PEERLESS FARMS CONSTRUCTION DOCUMENTS

16975 FALCON HIGHWAY, PEYTON, CO

PEERLESS FARMS
EL PASO COUNTY, COLORADO
COVER SHEET
CONSTRUCTION DOCUMENTS

DATE APPROVED: 12/31/05	Rural Local Roadway	
APPROVED: John A. McCarty	REVISION DATE: 12/22/05	FILE NAME: SD_2-11
DEPARTMENT OF TRANSPORTATION

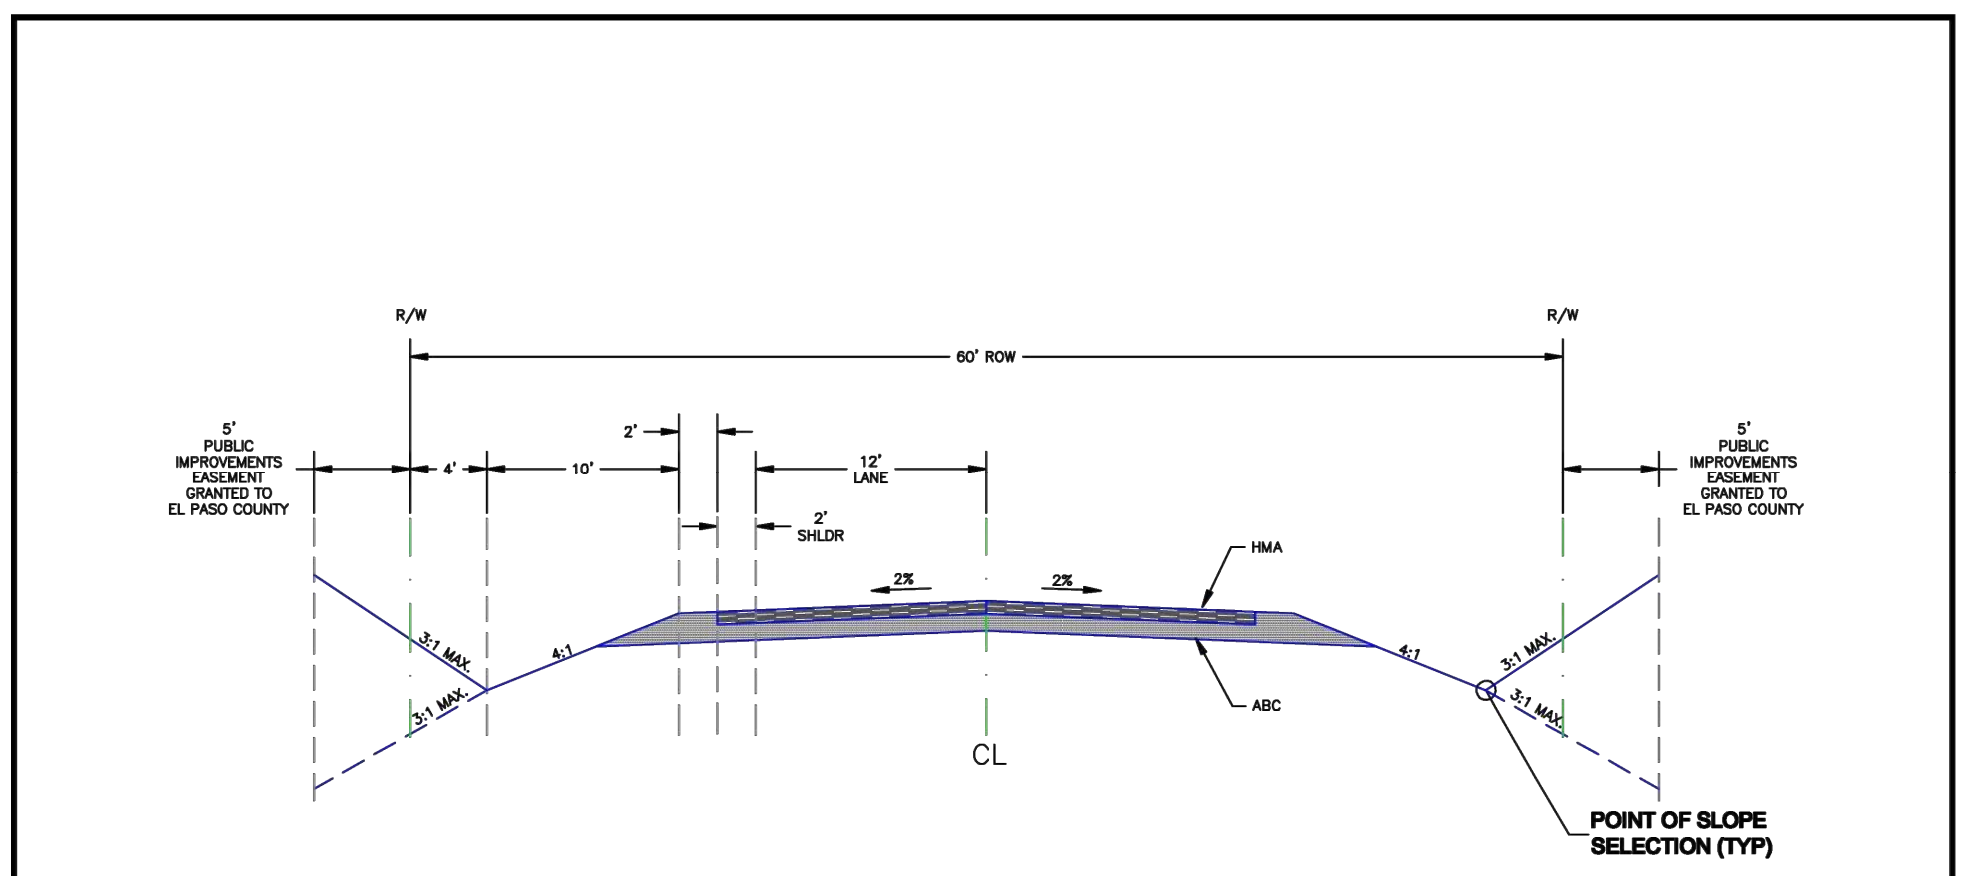
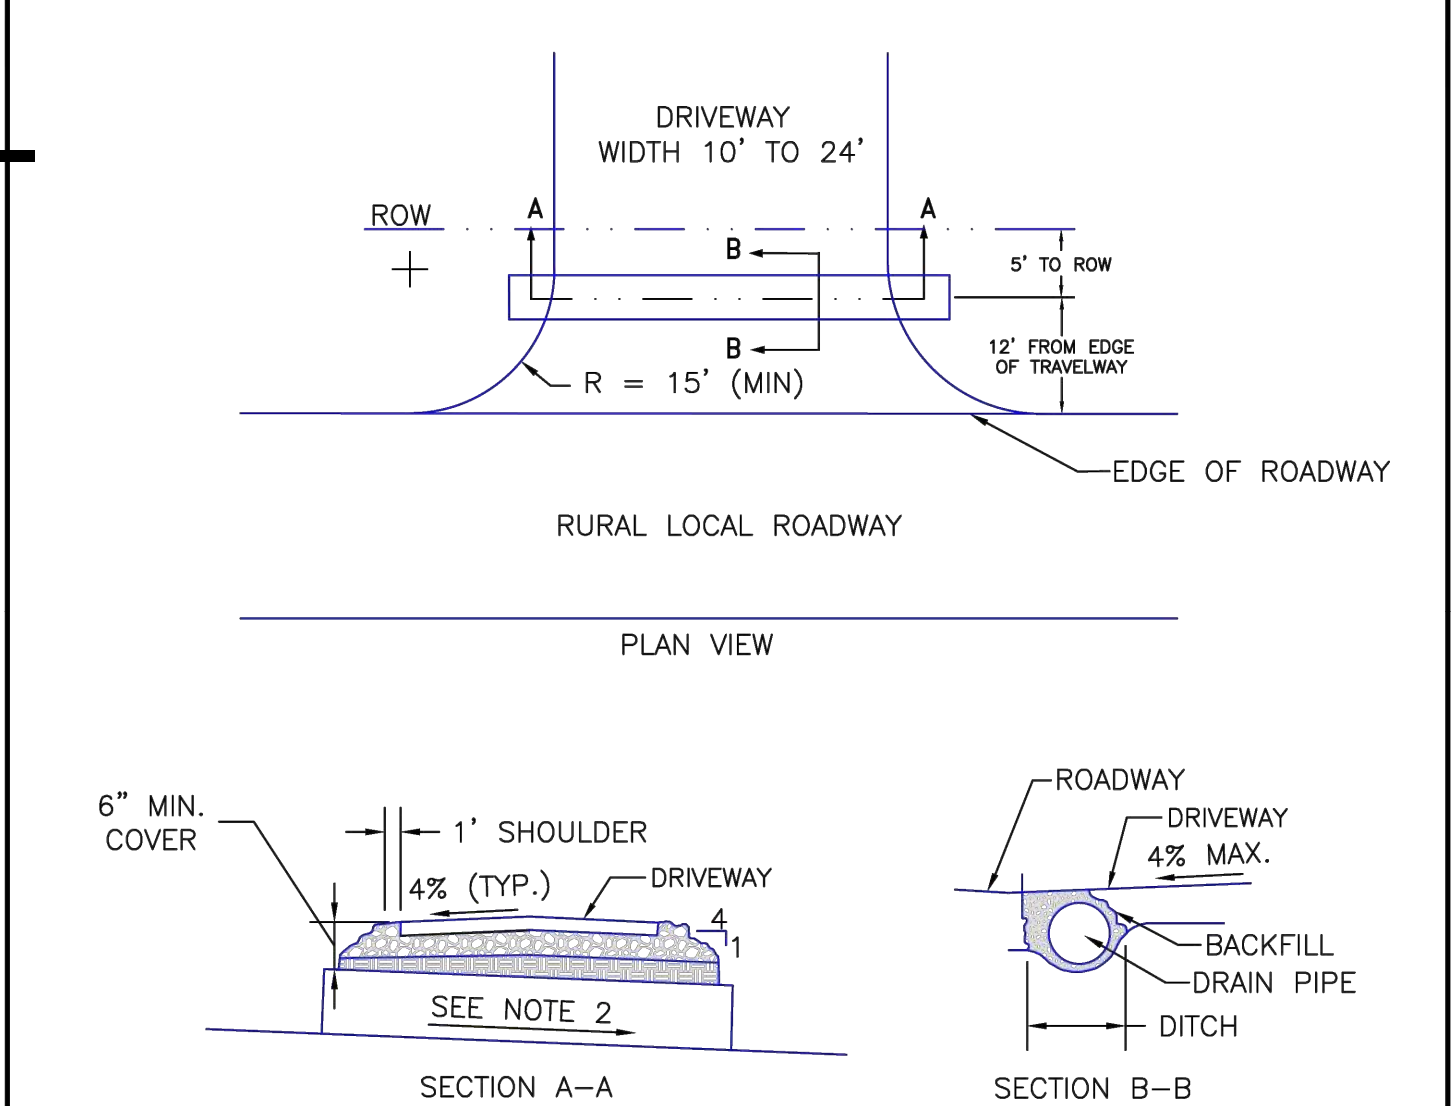
Unresolved from Submittal 1: Provide a detail of drainage ditch cross section with side slopes, min depth, etc.

Submittal 2 addition: The detail on sheet two shows two different cross sections, one that is not applicable it appears since the slopes are 4:1 and only one has a min depth listed. It needs to be clear the proposed side slopes (both front and back) and min depth for the construction of these ditches since they are providing drainage and water quality.

Thank you for your review. We discussed this with EPC staff on a conference call. Below is what we have done to resolve this comment.

1.) We have removed the EPC SD_2-10 from Sheet C2.1. That detail is for a Public Gravel road. Public gravel roads are not being proposed for this project and that detail was causing confusion. Any gravel roads for this project are only private gravel driveways.

2.) EPC SD_2-11 is included on Sheet C2.1. That detail provides a standard cross-section for roadside ditches for the Public Roadway. We have added a note about the roadside ditch minimum depth. I would prefer not to recreate the county standard detail as that will cause confusion and inconsistencies. Because of this, we added the minimum depth directly to the county standard detail. This detail makes the side slopes very clear (4:1 next to the road and 3:1 max. on the outside.) As far as the concern about the side slope as it relates to water quality, the 3:1 max side slope is not being counted towards the water-quality / runoff reduction area (except for a small portion where the stormwater can interface at the bottom of the roadside ditch), so whether that 3:1 max is 3:1 or 4:1 it does not matter because we account for the most conservative slope (as it accounts to capacity and infiltration water interface). We've graded things appropriately and our plans include the necessary ditch depths and side slopes for drainage and water quality.
